Subject: Millwood House, Littlehampton Road, Ferring, Worthing, West Sussex, BN12 6PG - FG/138/21/PL

Planning Application Reference: FG/138/21/PL

Proposal: Change of Use of land to open air storage (Class B8), including 12 equal sized open air storage yards, lighting and CCTV. This application is in CIL Zone 3 (zero rated) as other development.

location site

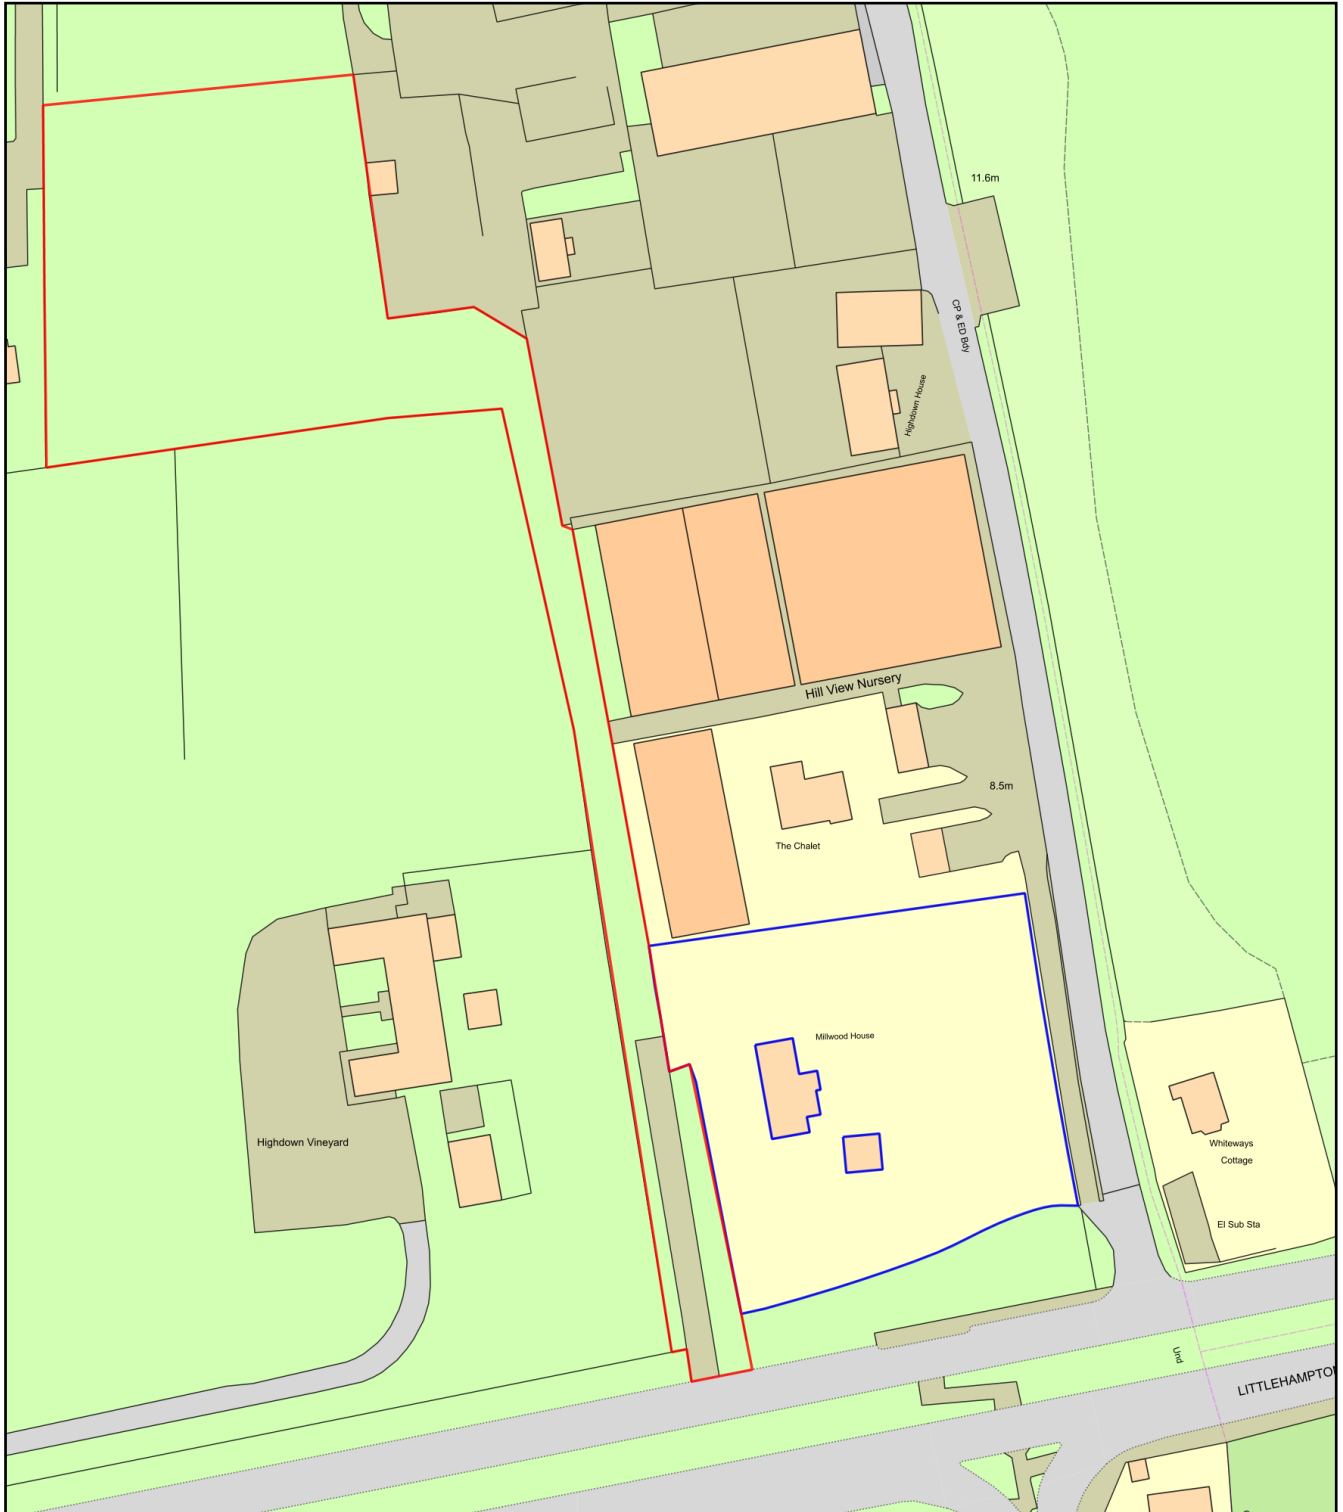
BEFORE THE FIRST OCCUPATION OR USE OF THE DEVELOPMENT the access roads and parking areas shown on the Location plan shall be completed with a hard surface finish and thereafter permanently retained for parking and manoeuvring purposes
